Re: Status of Improvement Permit Application #3-5-7219

On June 26, 2003, an Environmental Health Specialist from the Harnett County Health Department attempted to evaluate your property for the purpose of issuing an Improvement Permit. This individual was unable to evaluate your property for one or more of the following reasons.

SITE PLAN APPROVAL

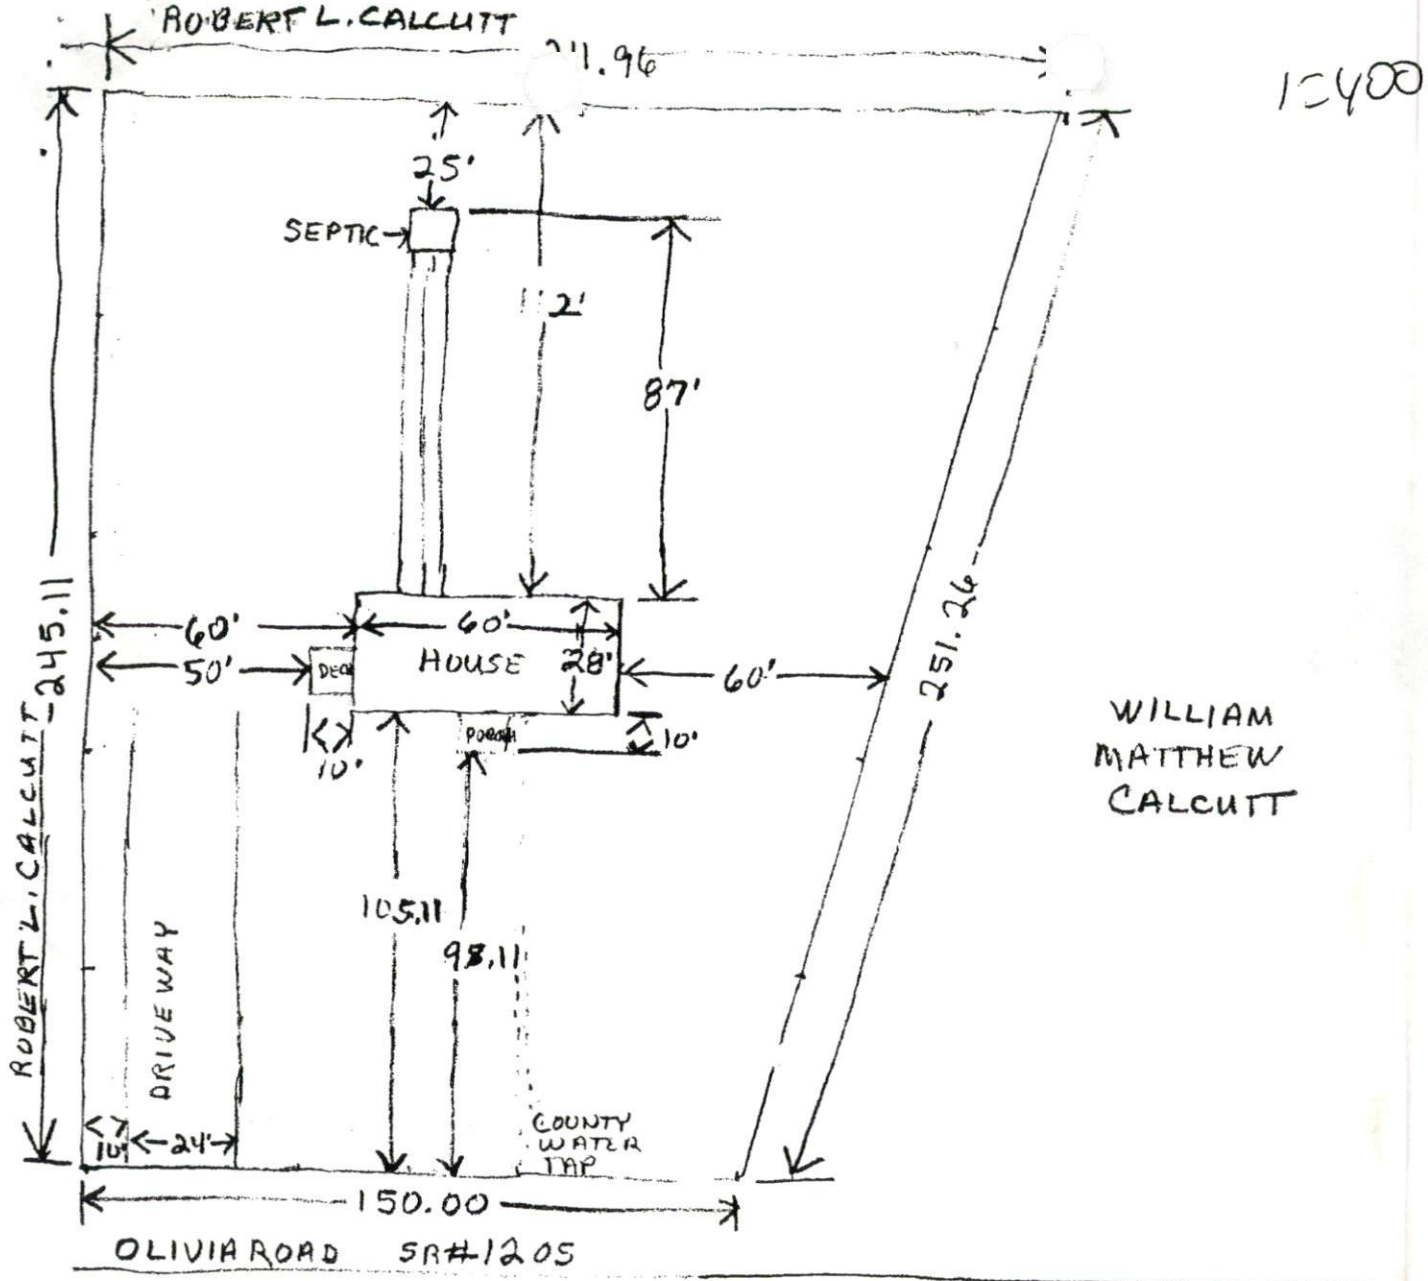
- 1. Property lines/corners not marked or labeled (Need the irons located at the rear of property.)
- 2. House corners not marked or labeled
- 3. Directions not clear to property
- 4. Property needs brush or vegetation removed
- 5. Backhoe pits required
- 6. Other: Flags for house size and setback off front property line do not match site plan.

When you have completed #1 & #6, please call 910-893-7547 to confirm that the items mentioned have been corrected, we will then reschedule your property for evaluation.
